**Re: Old Chevron Terminal at 3200 Broadway Blvd SE
Erosion and Sediment Control Plan
Engineer's Stamp Date 4/25/24 (M14E038)**

Principal Engineer, Planning Dept.
Development and Review Services

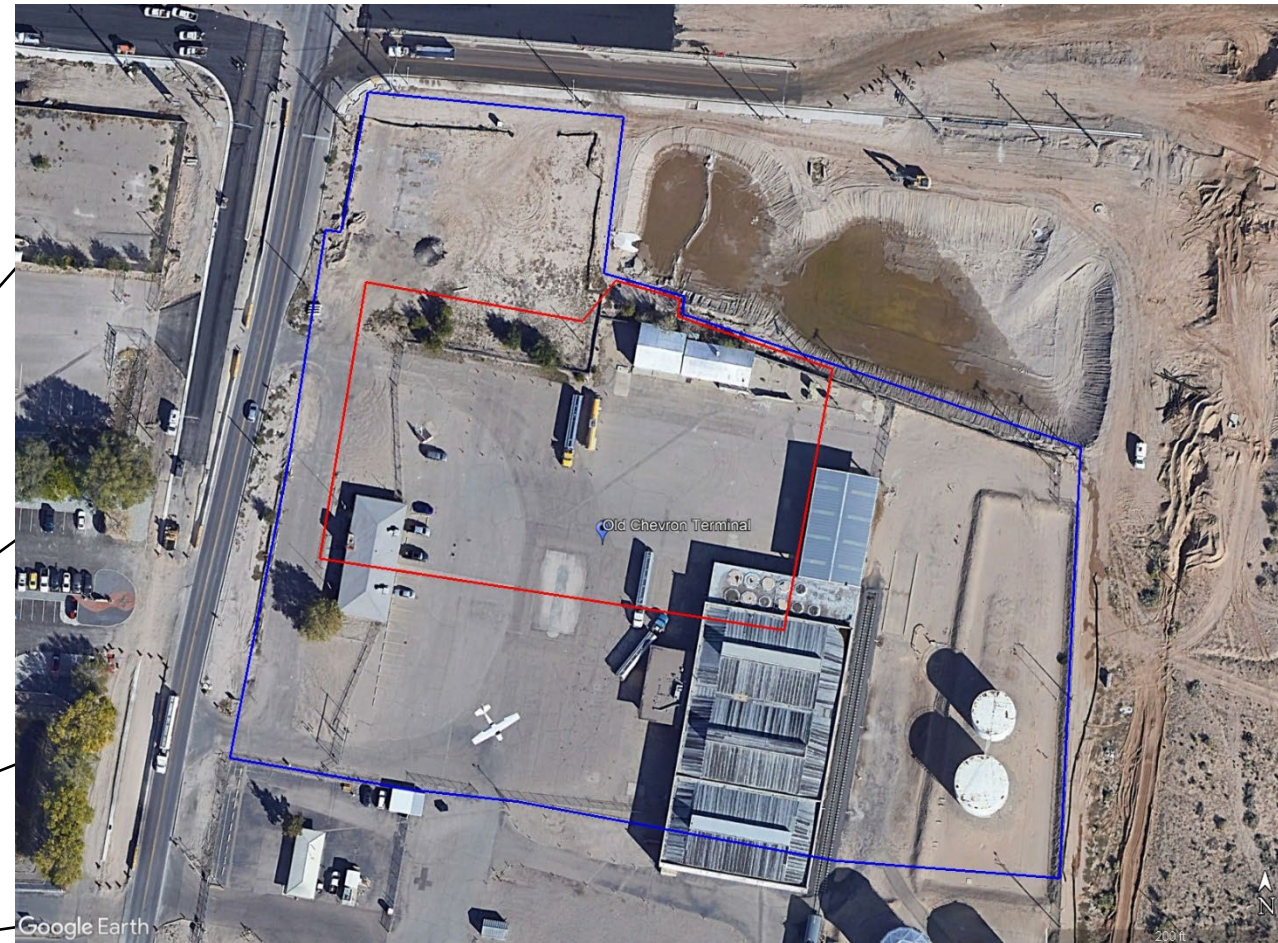
1. The ESC Plan can't be approved until after Hydrology approves the G&D Plan for each specific purpose, Site Plan, Grading, Building Permit, and Work Order. The only purpose Hydrology has approved so far is the Site Plan. The existing and proposed grades must be shown on the ESC Plan, and they must agree with the Grading Plan approved by Hydrology (CGP7.2.4.b.ii).

4. The downstream edge of this 7-acre site receives too much drainage for a silt fence alone. The Silt fence should be used in conjunction with berms and sediment basins sized to control the drainage from this 7-acre site per CGP 2.2.12. Sediment Basins must be designed and stamped by a registered Professional Engineer (PE), not a Certified Professional in Erosion and Sediment Control (CPESC). Your BMPs must be sized for the area that drains to them, all of the area, not just the onsite disturbed portion of the drainage area.

- c. Identify controls on the ESC Plan to minimize the exposure of PCB-containing building materials, including paint, caulk, and pre-1980 fluorescent lighting fixtures, to precipitation and stormwater. Separate work areas from non-work areas and construct a containment area so that all dust or debris generated by the work remains within the protected area.

SILT FENCE

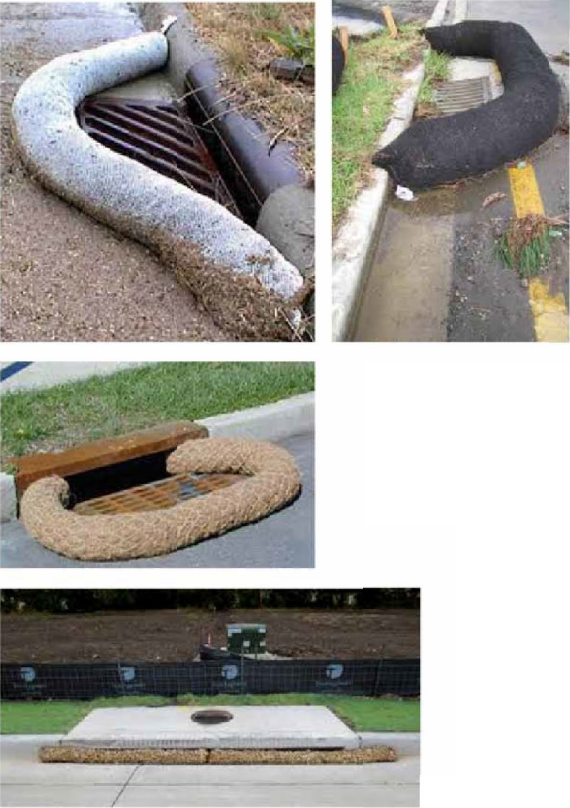
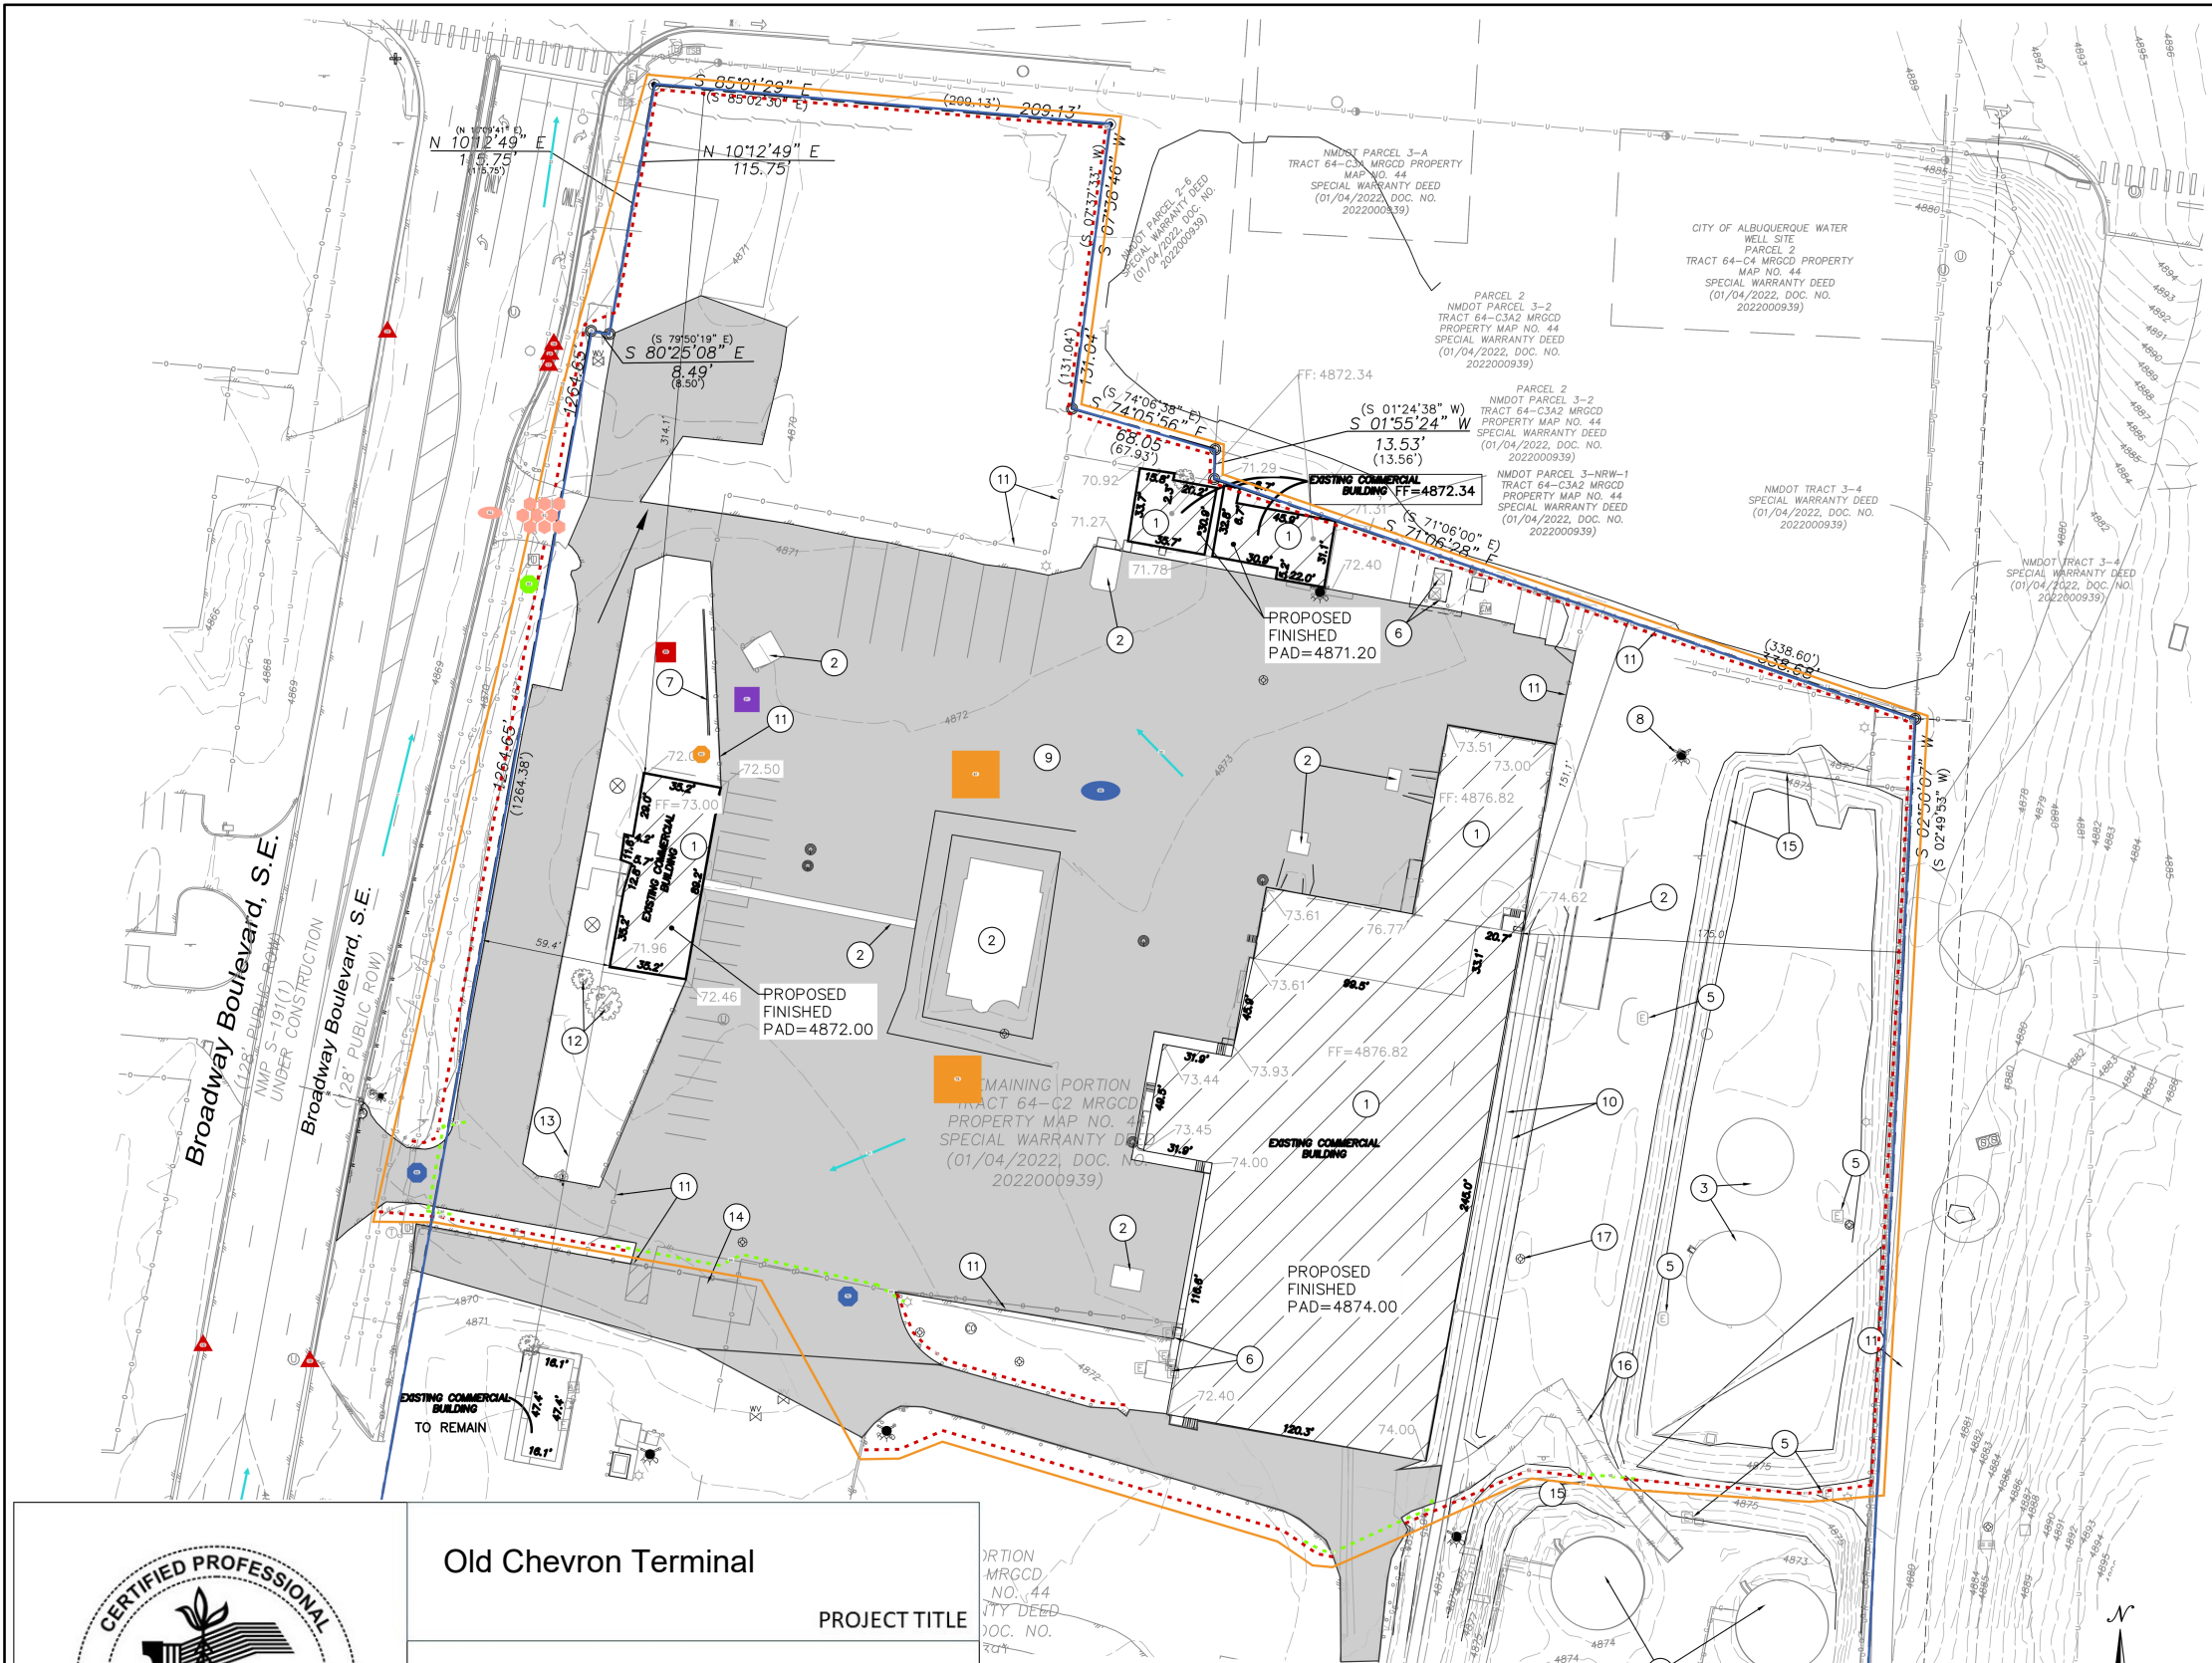
5. The SWPPP must describe design specifications, construction specifications, maintenance schedules (including a long-term maintenance plan), inspection criteria, and the expected performance and longevity of the BMPs per CGP 9.6.1.c.i. Specifications for "Weighted Gator Guard" and the other BMPs are missing from the SWPPP. Include all these specifications for the BMPs in the ESC Plan on the detail sheet(s).
